Environmental Health Consultation Response	Officer	Alan Taylor
---	----------------	--------------------

Detail: Planning request 3/2017/0629

Address:	116 Whalley Road Read Burnley Lancashire BB12 7PN			 Ribble Valley Borough Council www.ribblevalley.gov.uk
Application Ref:	36896	Case Officer:	Mr Adam Birkett	
Response Ref:	/ENV/01	Issue Date:	24 July 2017

proposed  
ground floor plan.

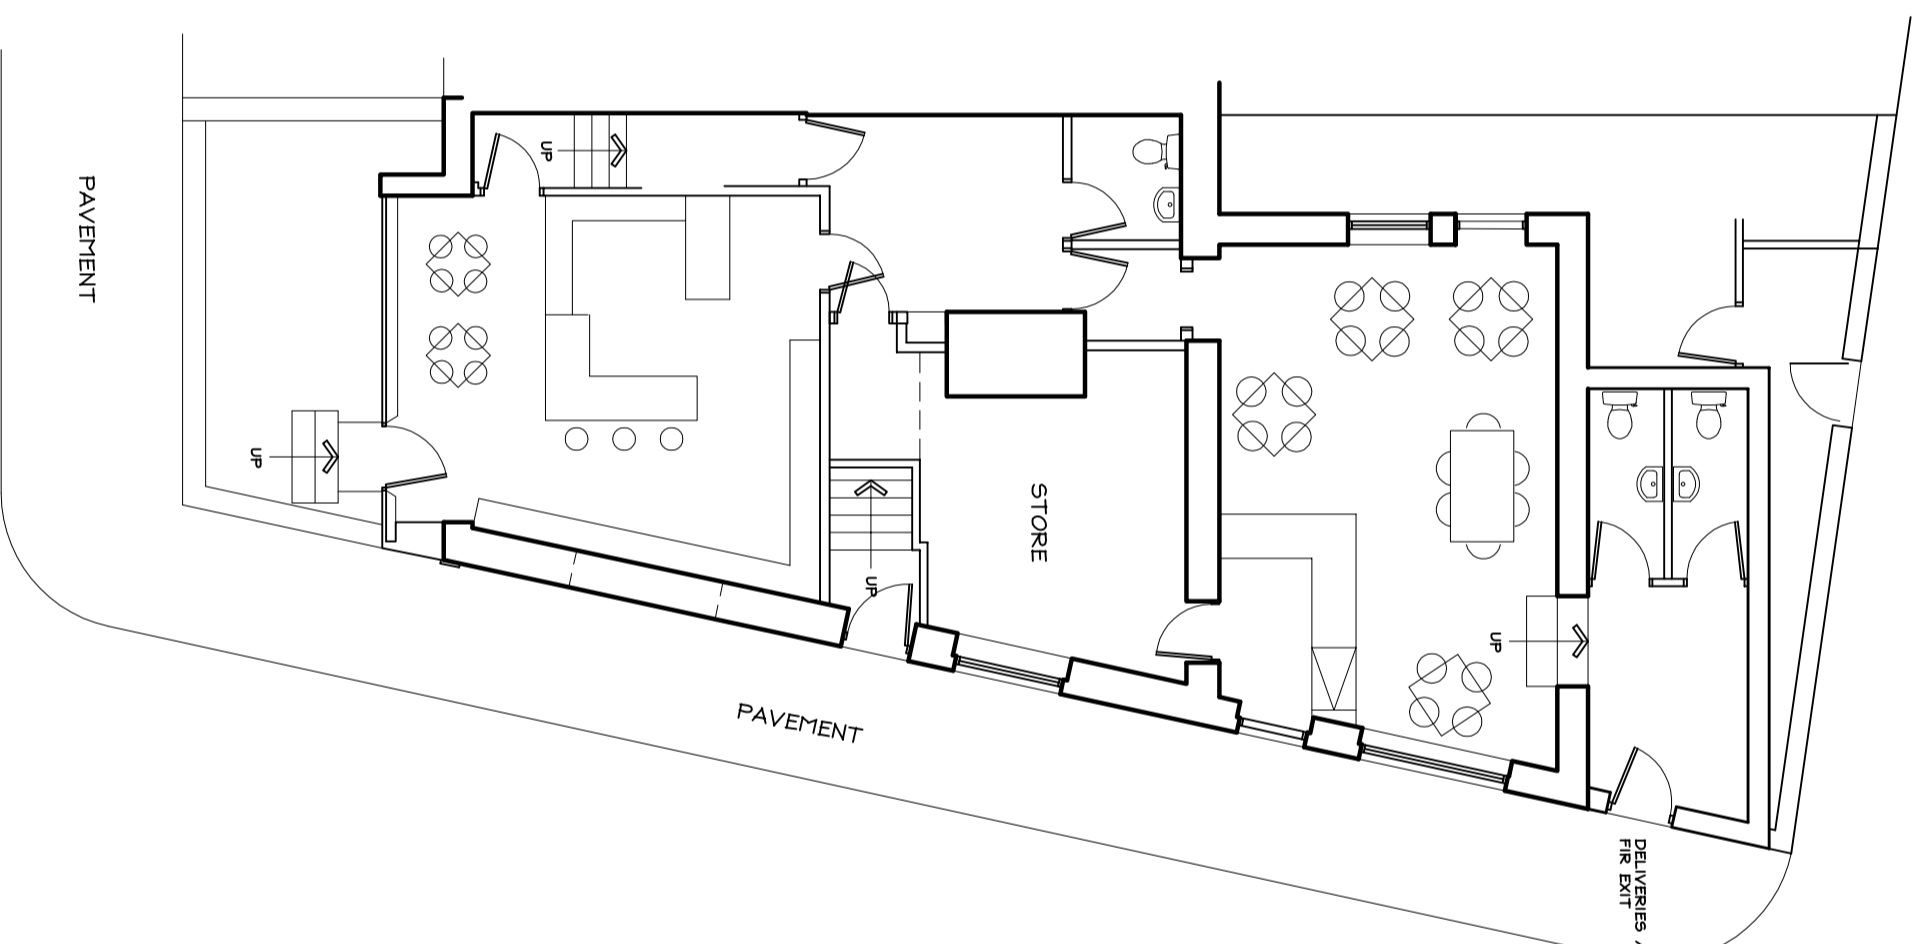
General Comments/Observations	
1.1	The planning application is to extend the current use of the Read Ale and Wines located on Whalley road in Read. As the proposed site is to extend from its current use of seating plan of 19 to 27 with access through a corridor which is along the partition wall with neighbour, concern is raised with the increased potential for noise to cause nuisance to neighbours next door and above. There is no indication from planning of the trading hours or limits on deliveries times. As there is potential to cause noise nuisance. A noise assessment would be a starting point to indicate the possible cause of noise nuisance and if the property is sufficiently insulated to prevent noise transfer between neighbouring properties. Any noise from drinking and any music should be identified as a possible source of noise nuisance and suggest areas where noise levels must be reduced or limited. Deliveries to the property should be limited to reduce any noise impact on neighbouring properties, also the emptying of used bottles into storage at the rear of the property. Is there a smoke policy?

Suggestions/Mitigation	
2.1	Suitable noise insulation needs to be identified where noise may transfer between neighbouring properties. A no smoking policy needs indicating to ensure no smoking inside the property or within the perimeter unless a dedicated smoking shelter is to be located, as this may cause complaints. Delivery times need to be indicated to prevent possible noise nuisance complaints.
Conclusions/Suggested Conditions

2.6	Sufficient noise insulation needs introducing to prevent noise transfer between properties should a noise assessment indicate noise transfer.
